## Response to the Applicant's Written Representation [REP2-082]

### Applicant's Internal Ref: WR44

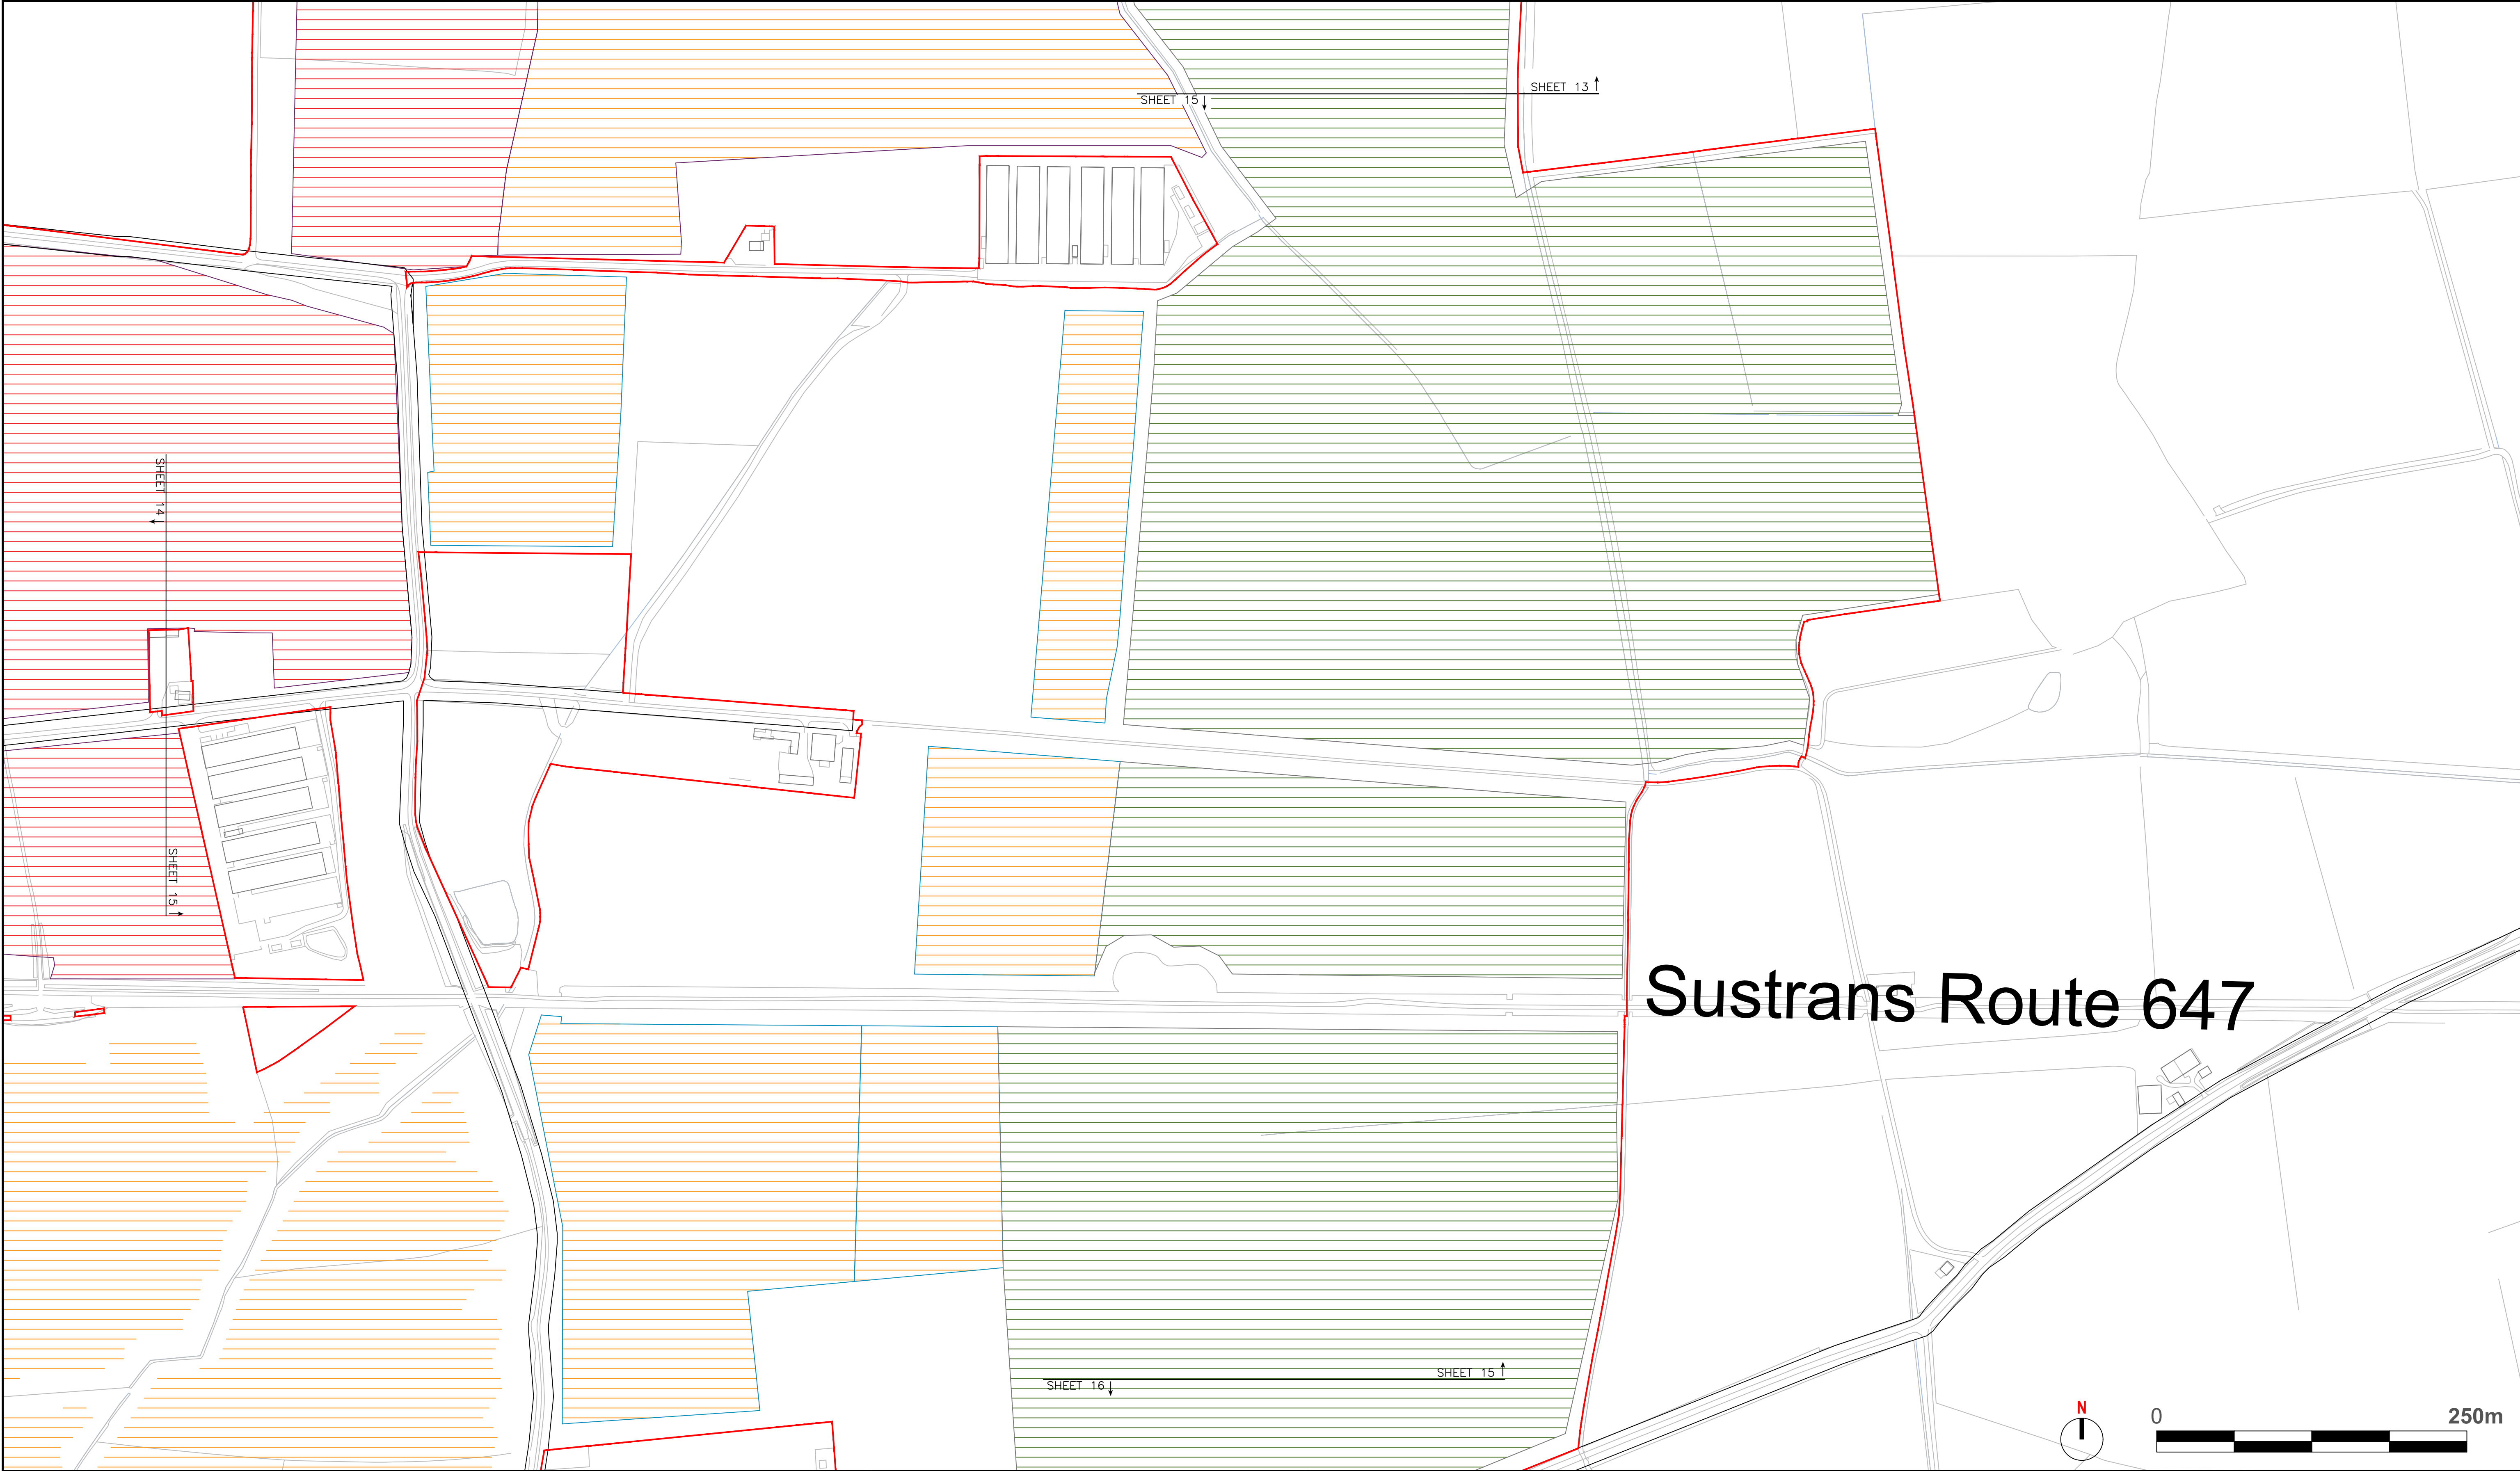
- **Principal views not correctly identified** – The Applicant records our principal views as only North and South. In reality, they are also to the east and far reaching due to the openness of the location. The angles of view marked on the drawing are not representative of what was discussed during the site visit.

- **Misleading commentary** – The drawing states “*Views to the south are limited.*” This is not correct. From our property we can clearly see far to the south, across the Sustrans route and over to Moor Lane, South Clifton.

- **“Part exchange” mitigation** – The Applicant notes “*Land to the north-east was extended in response to feedback.*” What has not been explained is that this extension was offset by removing mitigation land further west, much closer to our property, where panels have now been added. This was not an overall increase in mitigation. Furthermore, no land was removed to the south-east, despite my request, even though this is one of our principal views.

- **Misrepresentation of existing trees** – The Applicant shows our property surrounded by trees. While there are trees to the south of our garden, many are deciduous with a high trunk before the canopy begins. They do not block views, which remain open across the wider landscape.

- **Mill Farm Cottage** – The Applicant identifies principal views to the south and east. I have visited Mill Farm Cottage and spoken with the residents. Their true principal views are to the north (rear), north-west, south (front), and south-west. They specifically confirmed they do not have a principal view to the east. Despite

- **Moor Barn Farm** – This property does not appear to have been recognised as a dwelling at all; it is not recorded as visited or not. While some mitigation is shown, the area left free of panels to the east appears to coincide with an underground National Grid electricity cable. There are no identified principal views for this property, despite it clearly having both windows and a garden.
